## **Great North Road Solar and Biodiversity Park – Issue Specific Hearing 1 (ISH1)**

### **Summary of Verbal Representations from Newark and Sherwood District Council (NSDC)**

The following comprises a summary of the verbal representations of NSDC at ISH1 on the 26<sup>th</sup> and 27<sup>th</sup> November 2025. It is supplemented by additional comments as appropriate, where NSDC had further points to raise, but insufficient time was available within the hearings.

Drawing file: published-documents / EN010162-000329-GNR_6.3.17.2_ES_Figure_17.2_Provisional_Agricultural_Land_Classification_Wider_Area.pdf

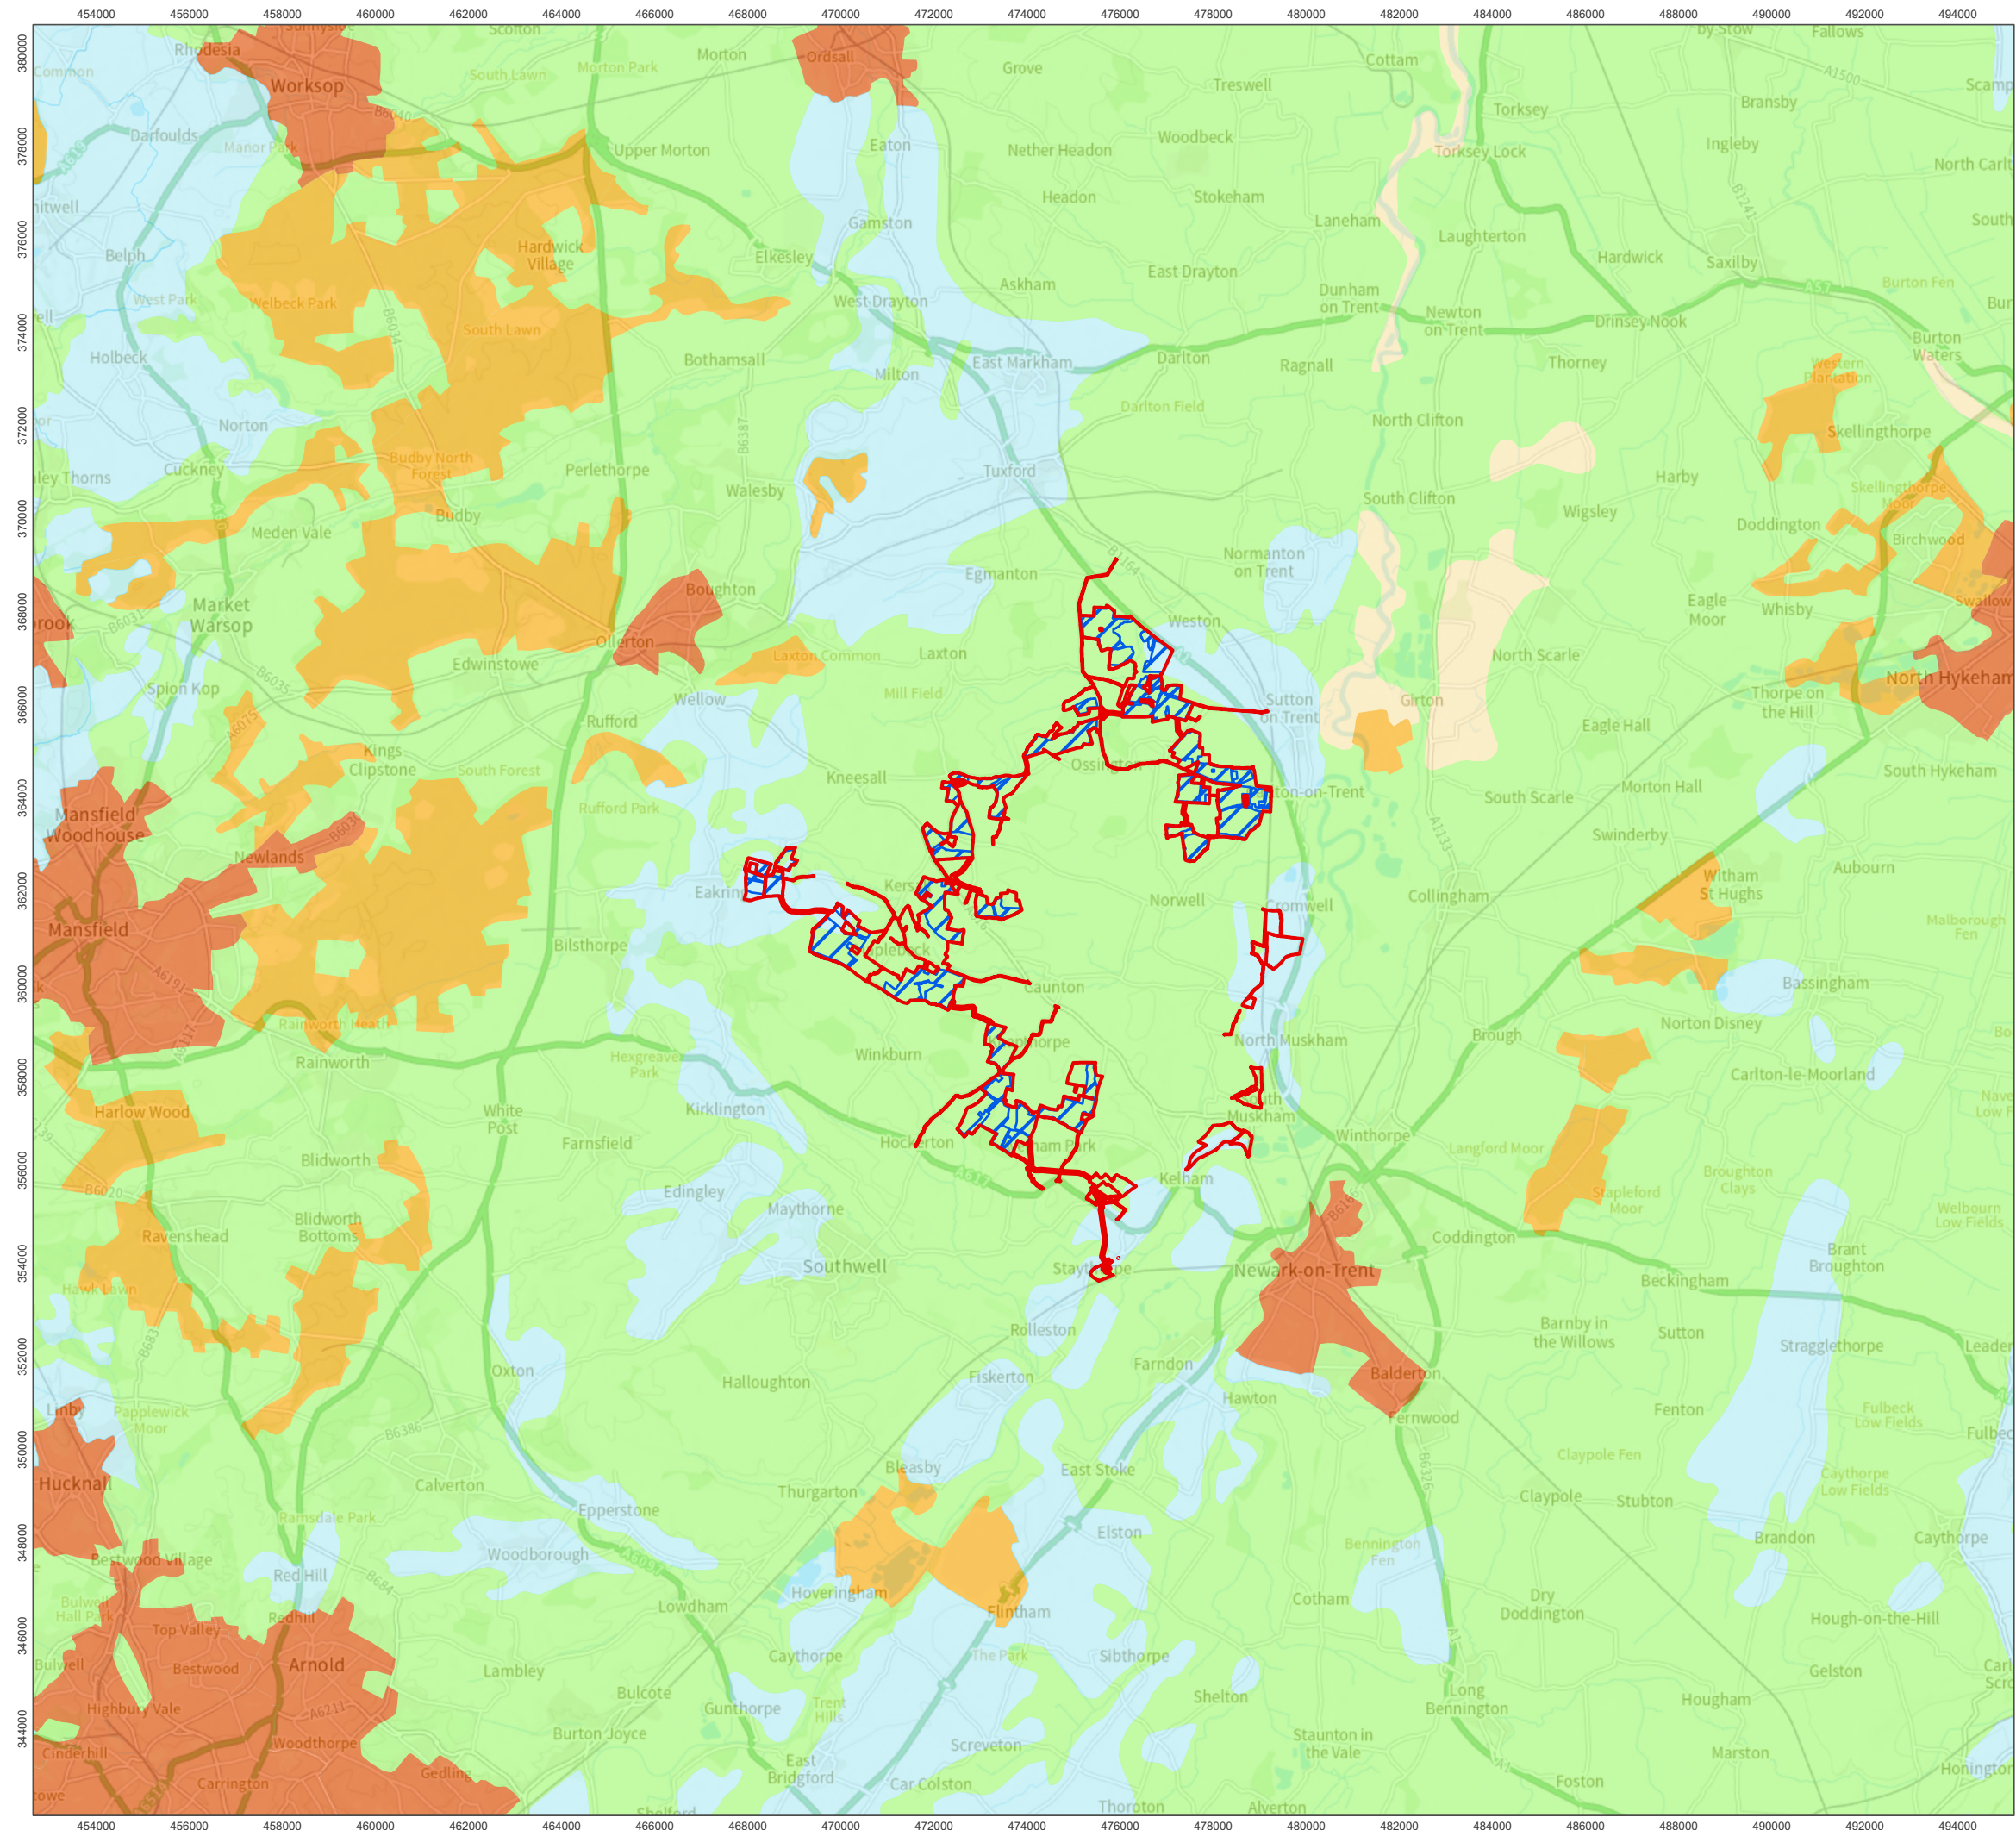
6. NSDC confirmed their view that within the national policy context for NSIPs, there is a clear preference for the use of poorer quality BMV land and the use of higher value BMV land should be avoided, wherever possible. NSDC stated that they had expressed concern on the issue of impact on BMV land since the pre-submission consultation stage and that continued to be concerned that a total of 62% of BMV land would be impacted, of which 8% is Grade 2 land, which is considered a considerable amount in the context of the size of the scheme.

7. NSDC raised the question as to whether other areas of land could have been considered that involved less amount of BMV land, particularly with reference to the Grade 2 land impacted by the proposed development, noting that Chapter 4 of the ES also offers no detailed analysis on alternatives in this respect.

8. During the ISH1, NSDC made reference to Figure 17.4 (Likelihood of Best and Most Versatile Land – Wider Area) which was displayed on screen and noted the large areas of moderate and low likelihood of BMV land within the inner areas of the Order Limits area, which suggests a clear alternative exists to the use of as a minimum Grade 2 BMV land and would likely reduce the overall amount of BMV impacted.
